Arun District Council
Arun Civic Centre
Maltravers Road
Littlehampton
West Sussex BN17 5LF
Planning & Building Control General Enquiries
Tel: (01903) 737756 Fax: (01903) 730442
Dx: 57406 Littlehampton
Minicom: 01903 732765
e-mail: planning@arun.gov.uk
website: www.arun.gov.uk/planning

Application No: Y/82/20/RES
Site Address: Land to the south of Ford Lane and East of North End Road Yapton BN18 0DS
Description of works: Approval of reserved matters following outline consent Y/80/16/OUT for 4.5ha of residential development comprising of 3.4ha of land for the erection of 100 No. dwellings (up to 30 (30%) affordable housing) together with 1.1ha of land set aside for public open space, strategic landscaping, 2.2ha of public open space, green corridors with vehicular access from Ford Lane & pedestrian/cycle access only from North End Road (resubmission following Y/19/20/RES). This application may affect the setting of listed buildings, affects the character & appearance of the Church Lane, Yapton Conservation Area & affects a Public Right of Way. This site falls within Strategic Site SP2 (Zero Rated).

Thank you for your internet representation made on 29th October 2020 which has been

Title:
APARTMENT A
FLOOR PLAN AND ELEVATIONS

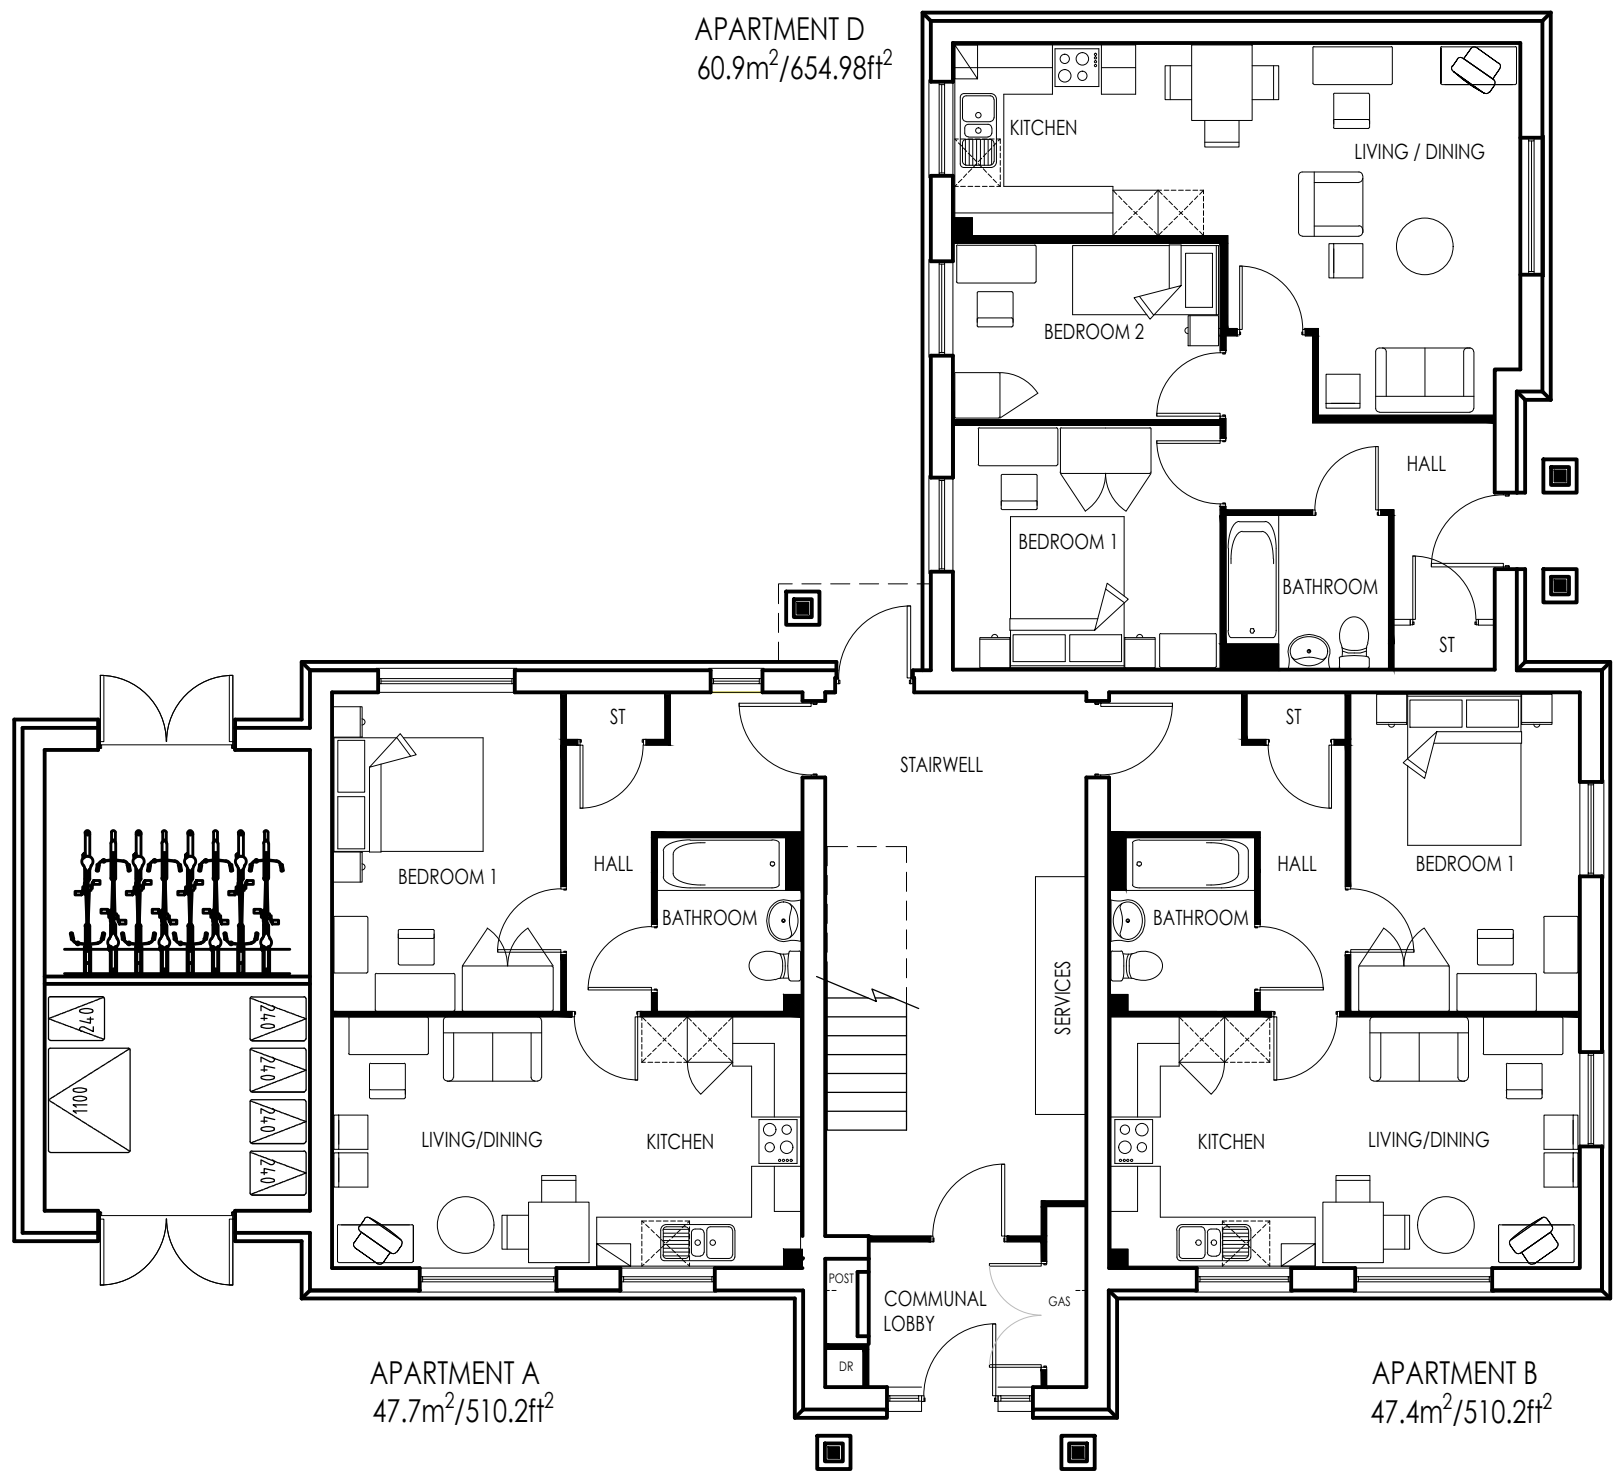
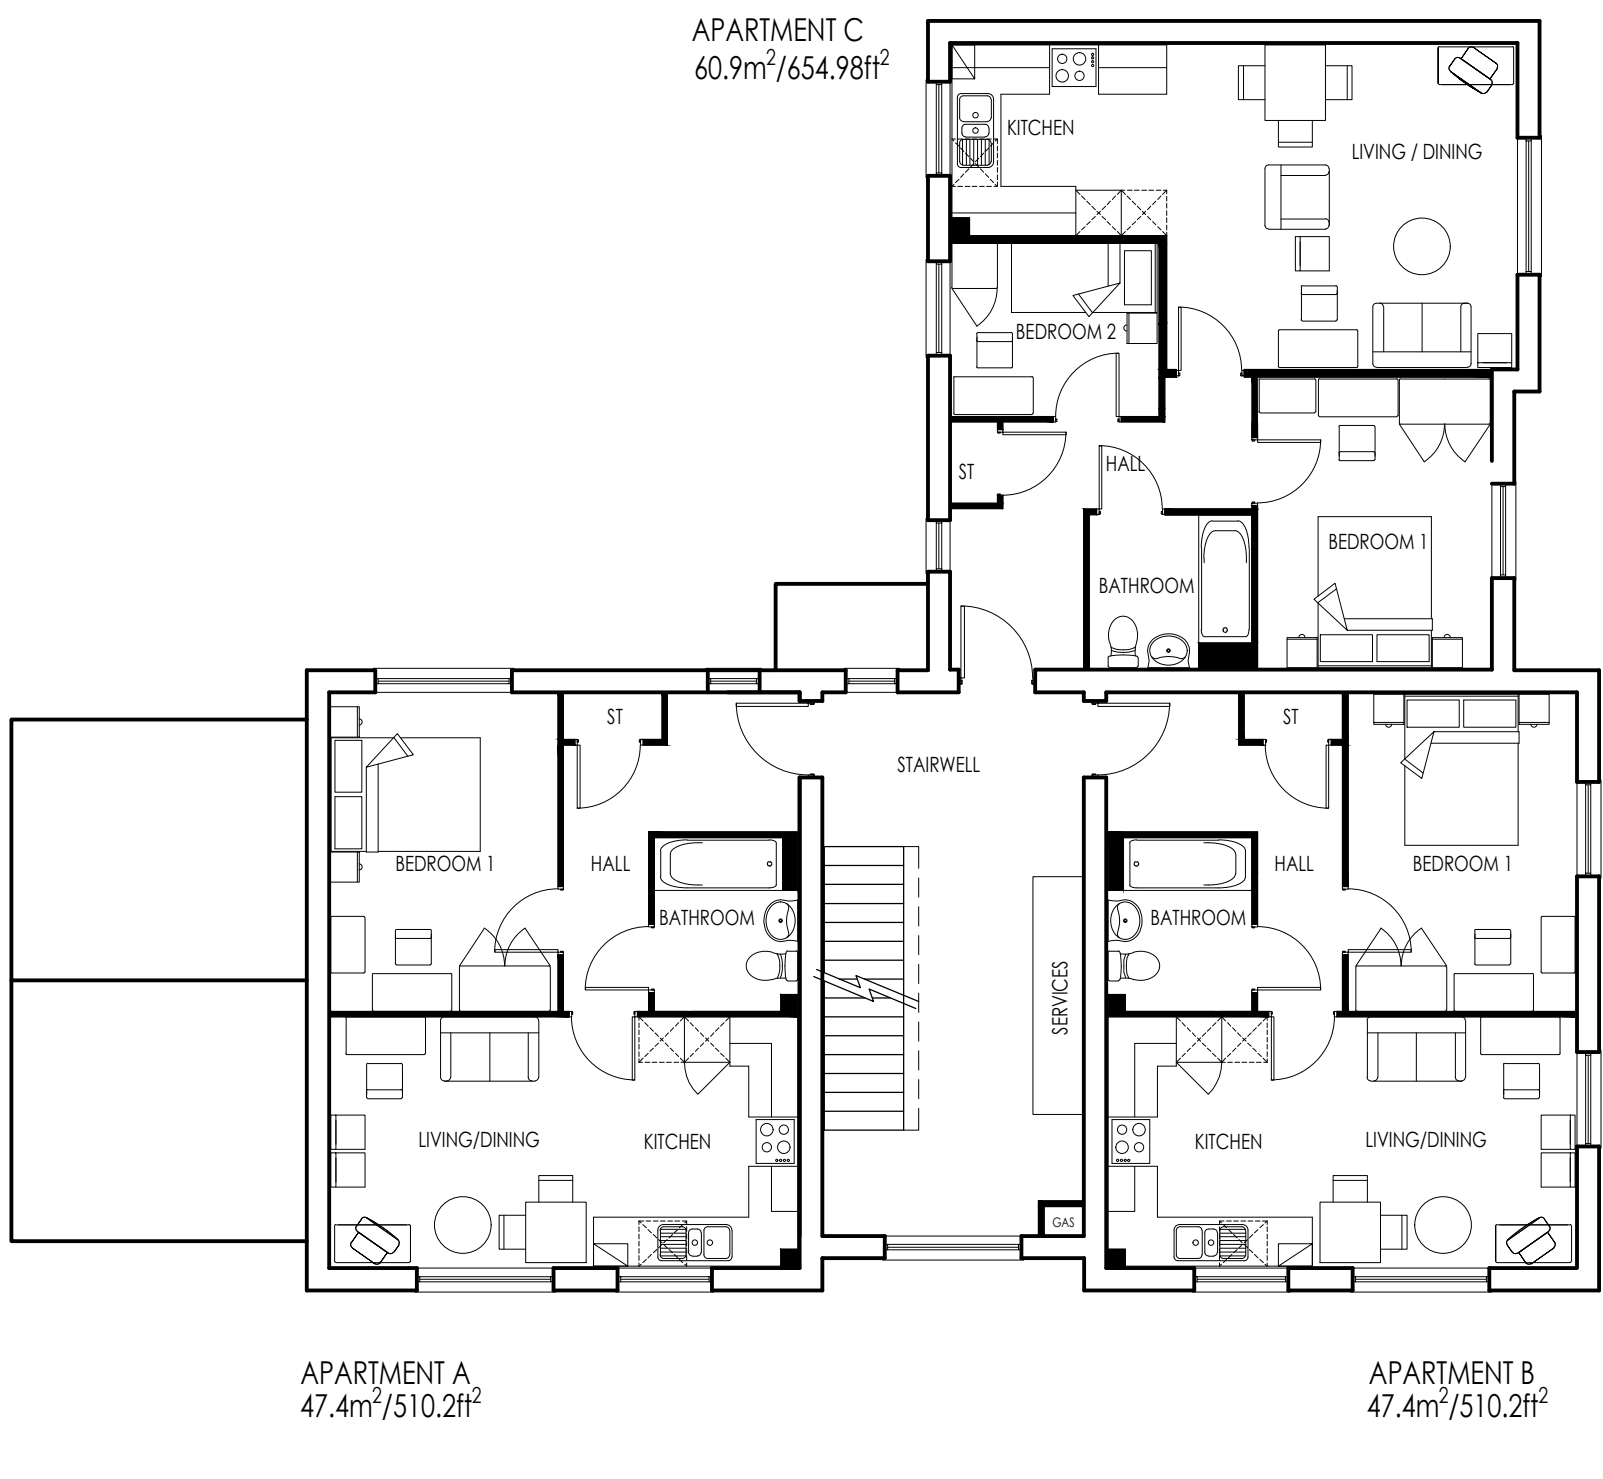
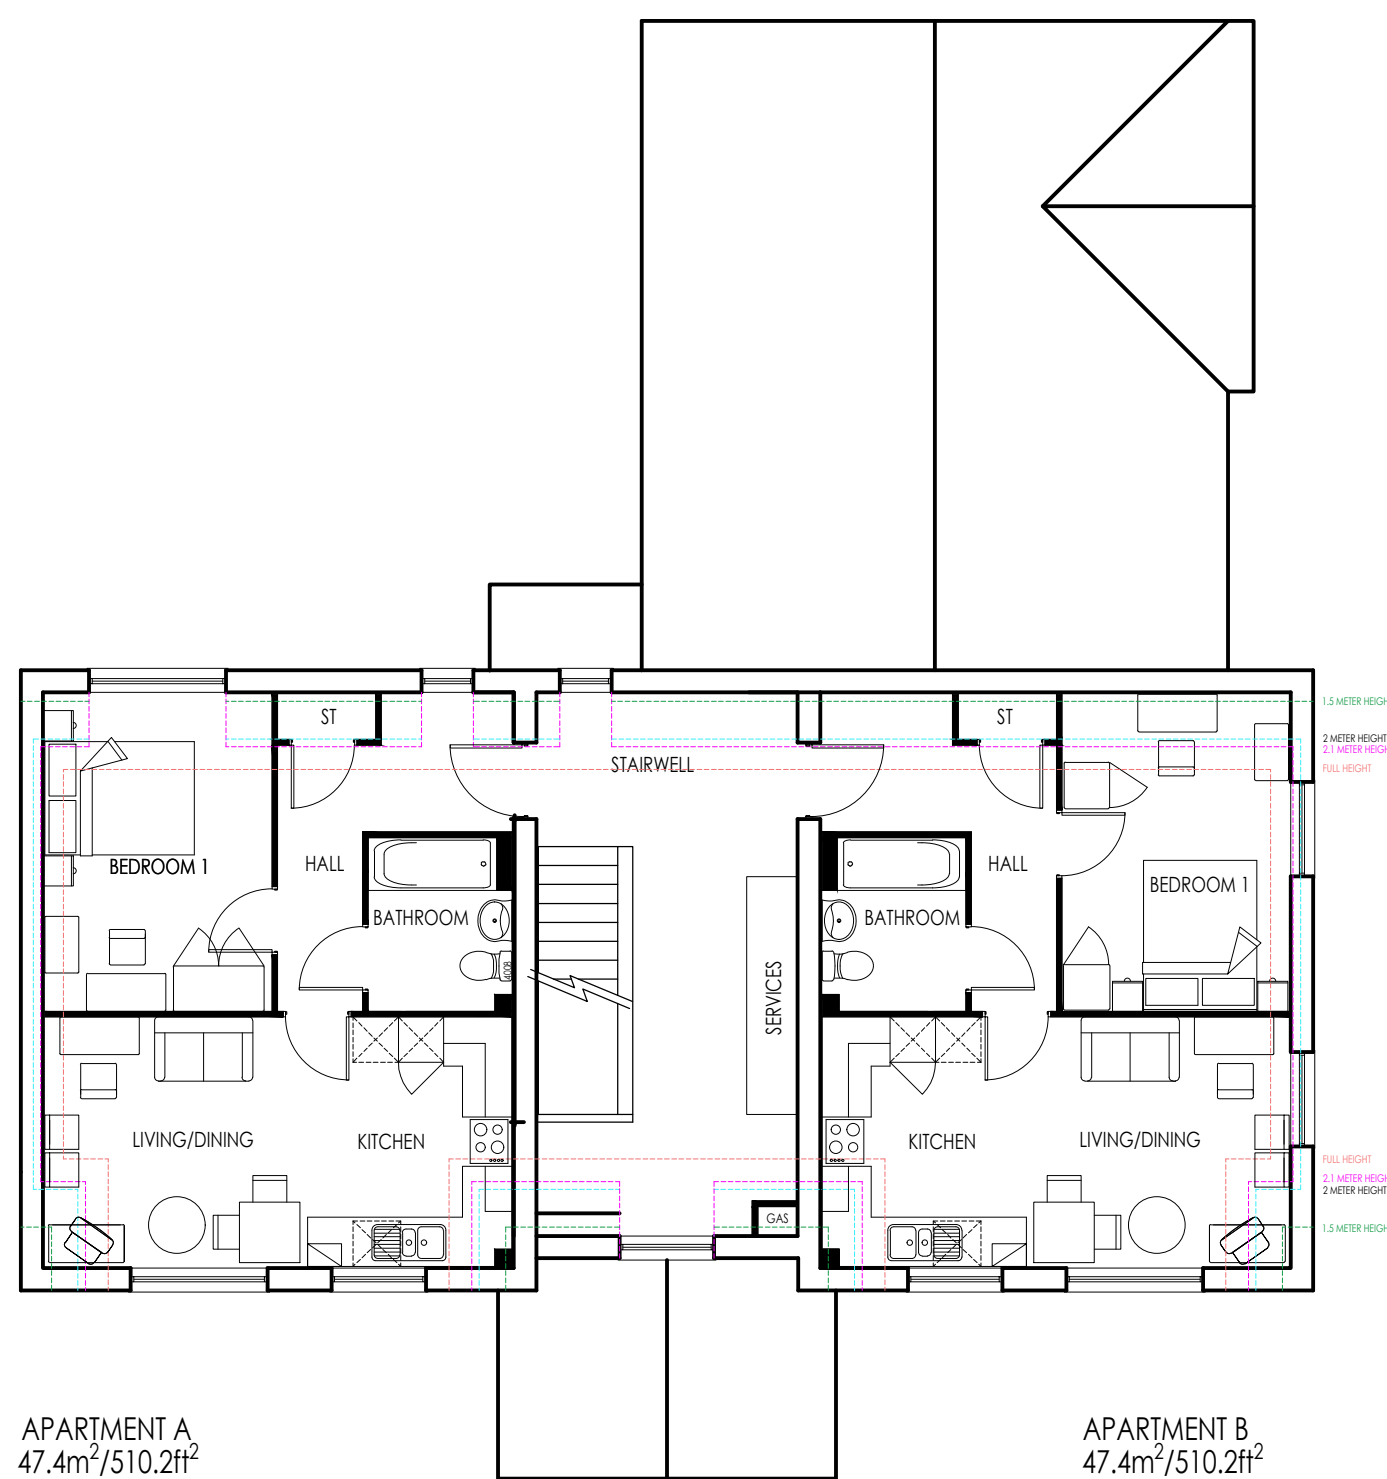
YPC acknowledge that Redrow have reduced the height of the flats fronting North End Road marginally. However, YPC remain concerned with the impact high buildings fronting this section of road will have on the streetscape of predominantly open fields and dwellings of no more than 2 storeys in height. Indeed, it should be noted that Yapton Parish, has very few buildings over 2 storeys in height excepting historic buildings such as Bonhams, Berricourt, St Mary's CofE Church.
